**Consultation Response from KC,
Lead Local Flood Authority**

2025/90372 Land at, Edgerton Road, Edgerton, Huddersfield, HD3 3AA

Discharge of details reserved by conditions 6, 7, 8, 9 (drainage), 11 (lighting scheme), 14 (Arboricultural Method Statement), 19 (Construction Method Statement), 21 (estate road), 22 (highway works), 23 (boundary treatments) on previous permission 2017/91916 for variation condition 23 (highway works) on previous permission 2014/93014 (APP/Z4718/W/15/3002523) for outline application for residential development comprising of 41 dwellings plus associated works (within a Conservation Area)

Date Responded: 16th March 2025

Project : Clayton Fields  
 Chamber Number : 12  
 Chamber Name : S12

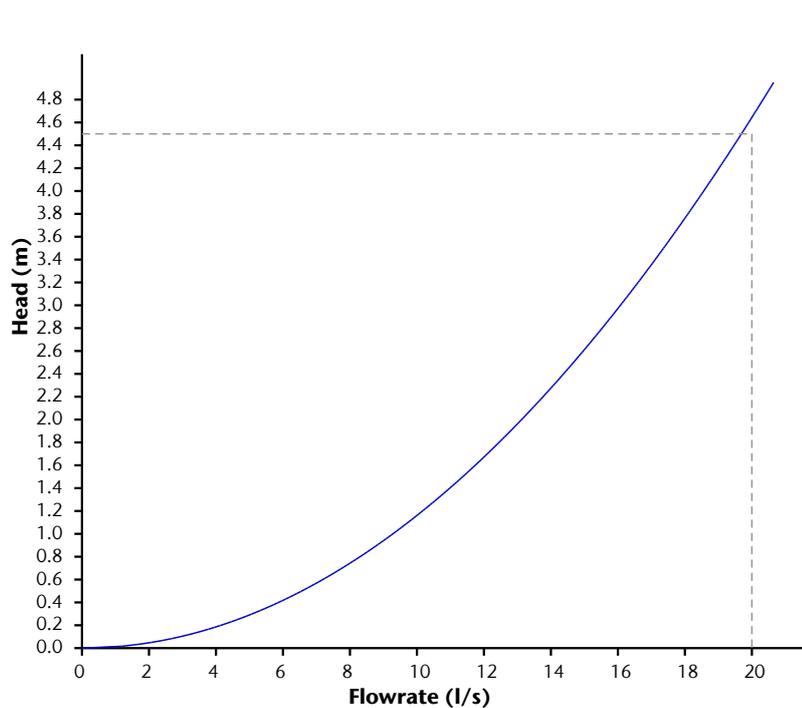
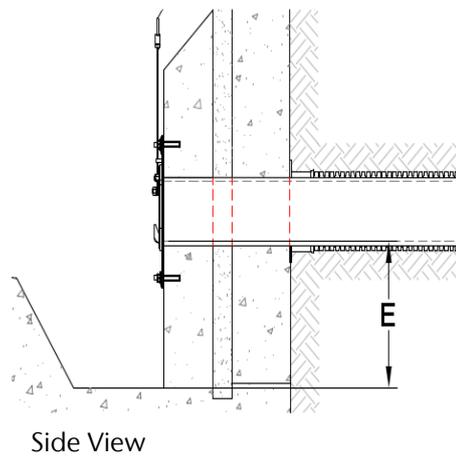
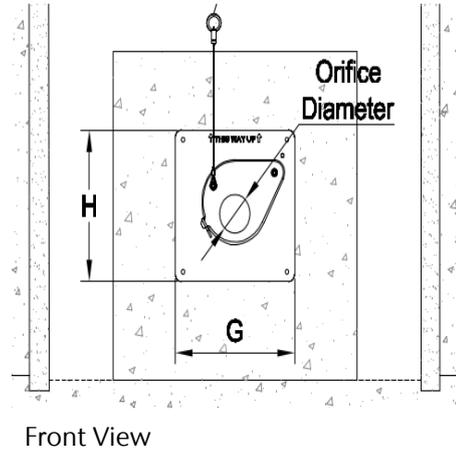
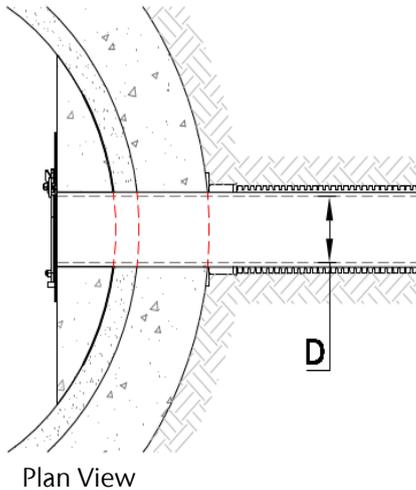
The flow control in manhole S12 has an orifice of 65mm. This is not acceptable. Kirklees Council LLFA advises that openings of 100mm are desirable and an absolute minimum of 75mm will be considered in order to lower risk of blockages and subsequent flooding.

Flooding is shown from manhole S12 in a 1 in 100 year + climate change event. This is unacceptable given there is 22 cubic metres of flooding.

SECTION THROUGH PROPOSED SURFACE WATER LAND DRAIN
Scale 1:20

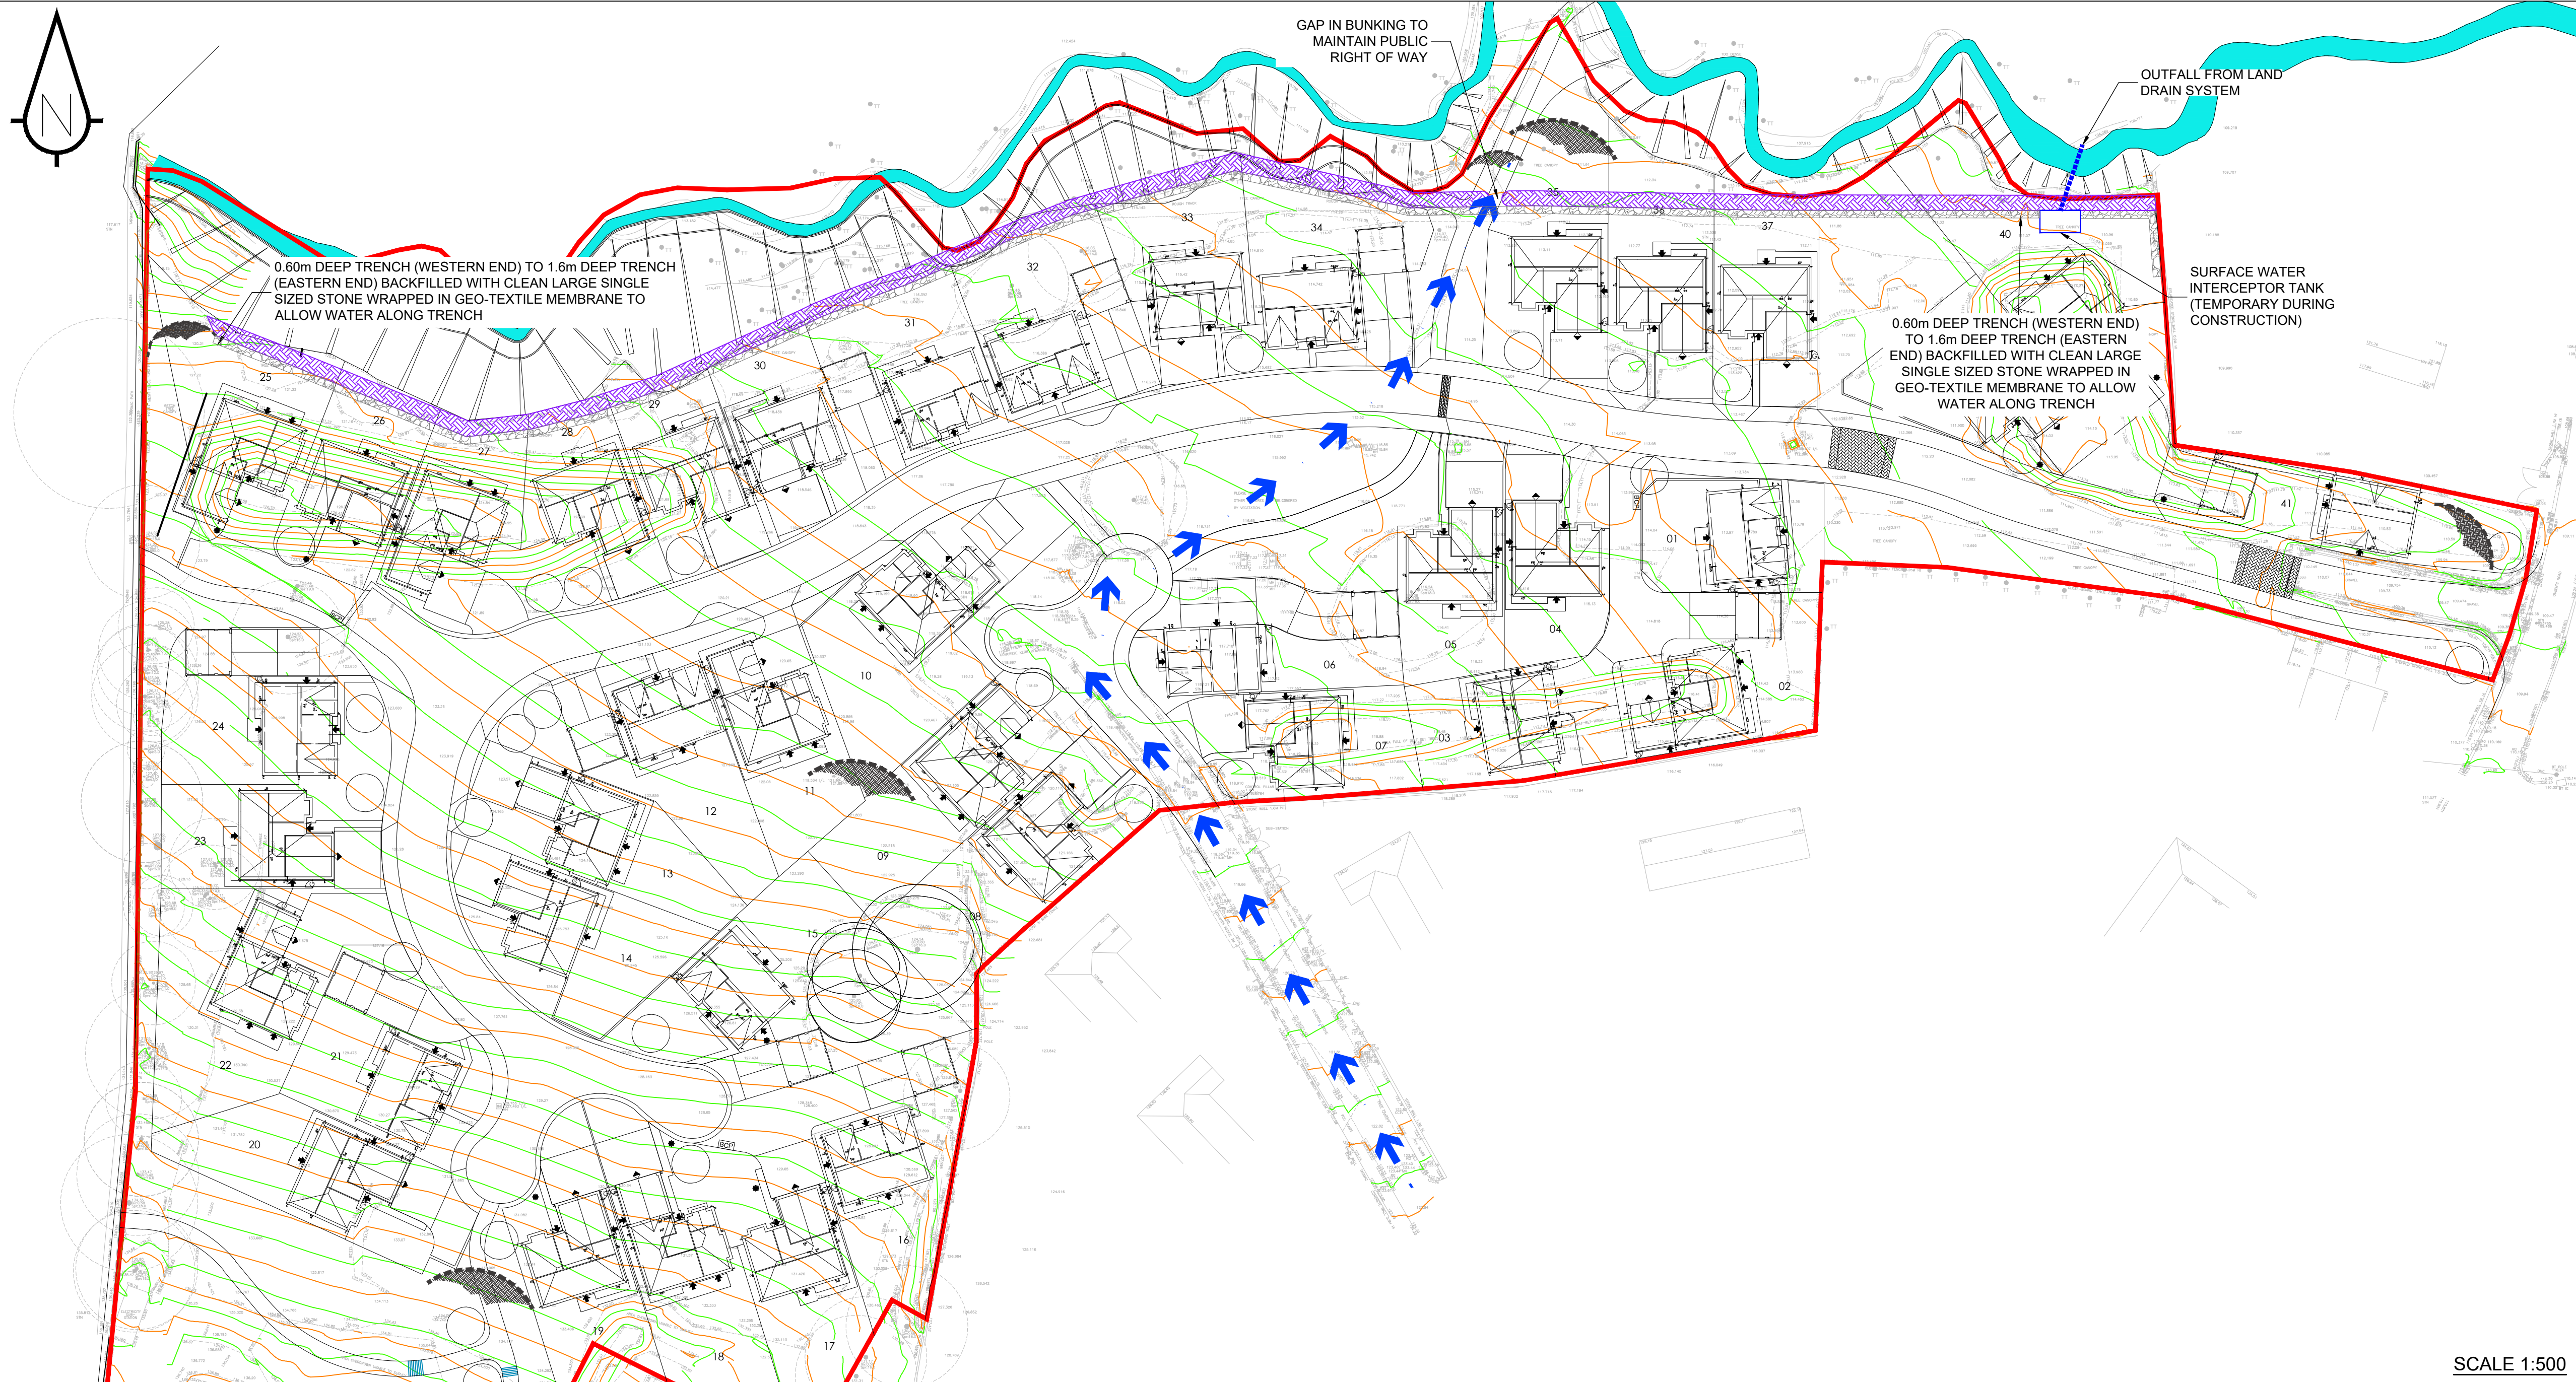
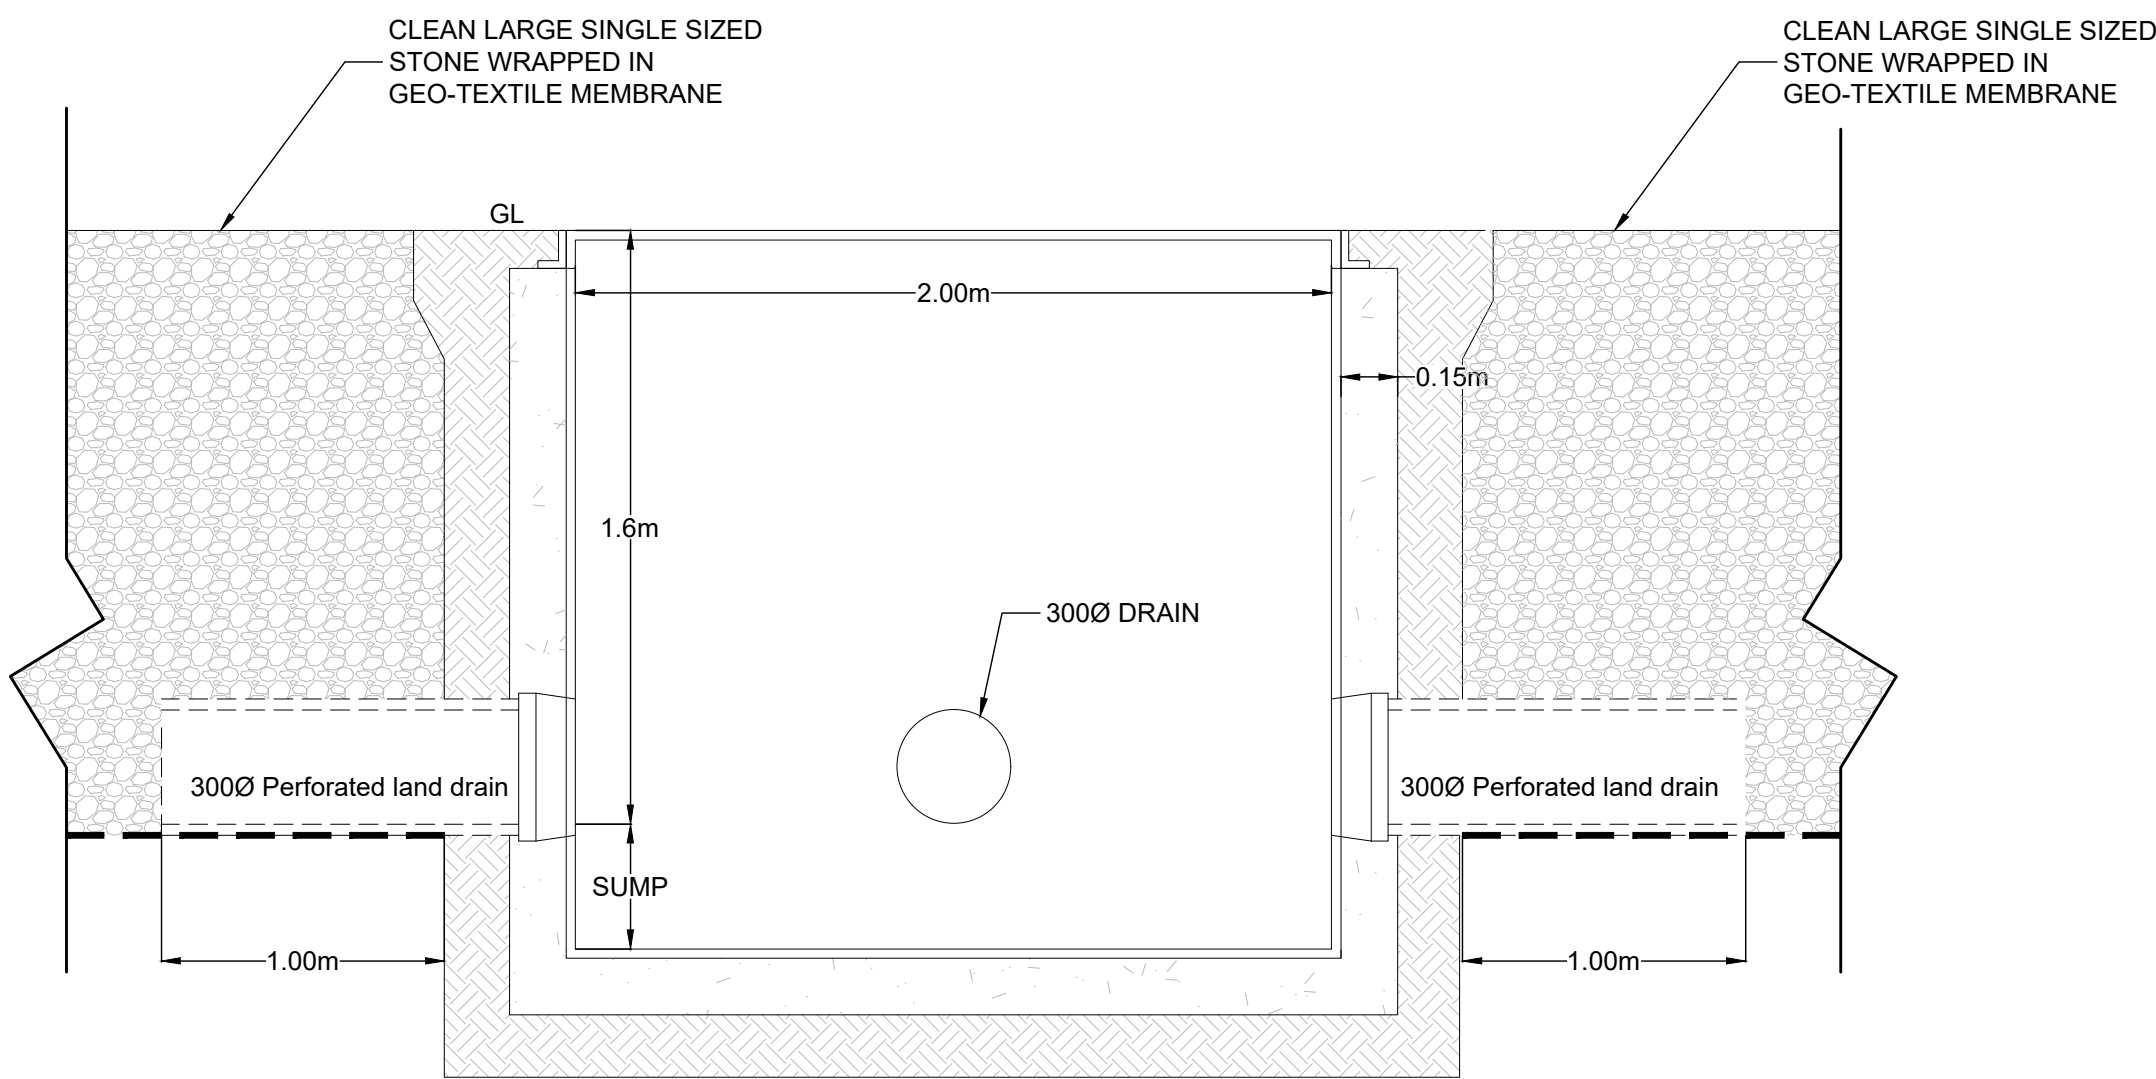
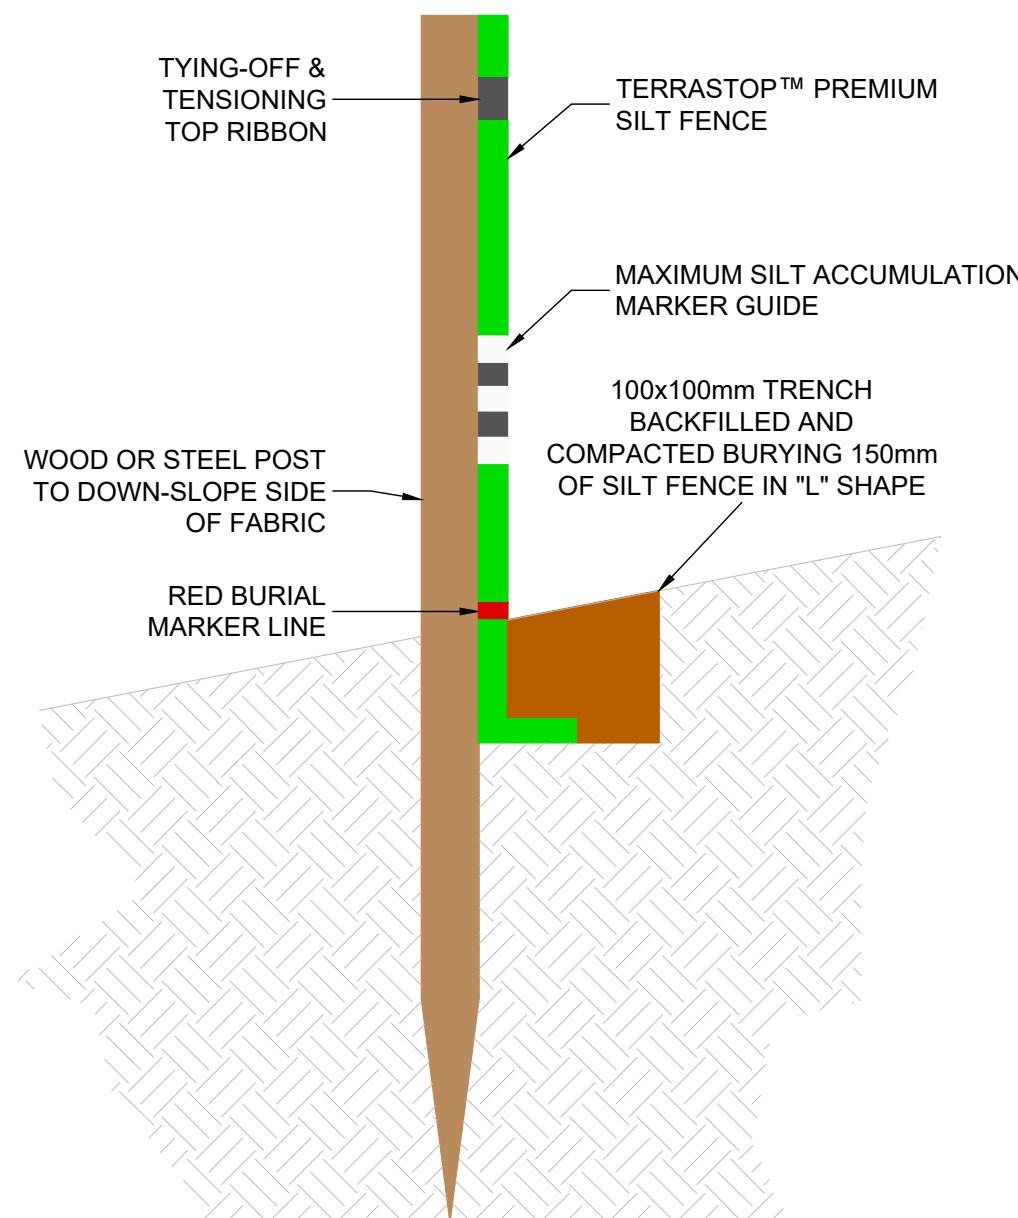
A bund is shown directing the water to a gap with a land drain (stoned) used to take some sediment out of flows. It does not appear to keep water on site with a restricted flow to watercourse. For a site this size, a 1 in 2-year critical storm must be retained on site.

A narrative should look at phasing of the construction phase and where and when work is going to take place. Back ups to plans should also be considered including flocculation and tankers should the original plan prove inadequate. The narrative should also look at the stage after permanent drainage has been installed and how flow and sediment control is achieved as work continues.

We advise to attempt to minimise soil and vegetation strips so that clean run off can pass straight through to watercourse.
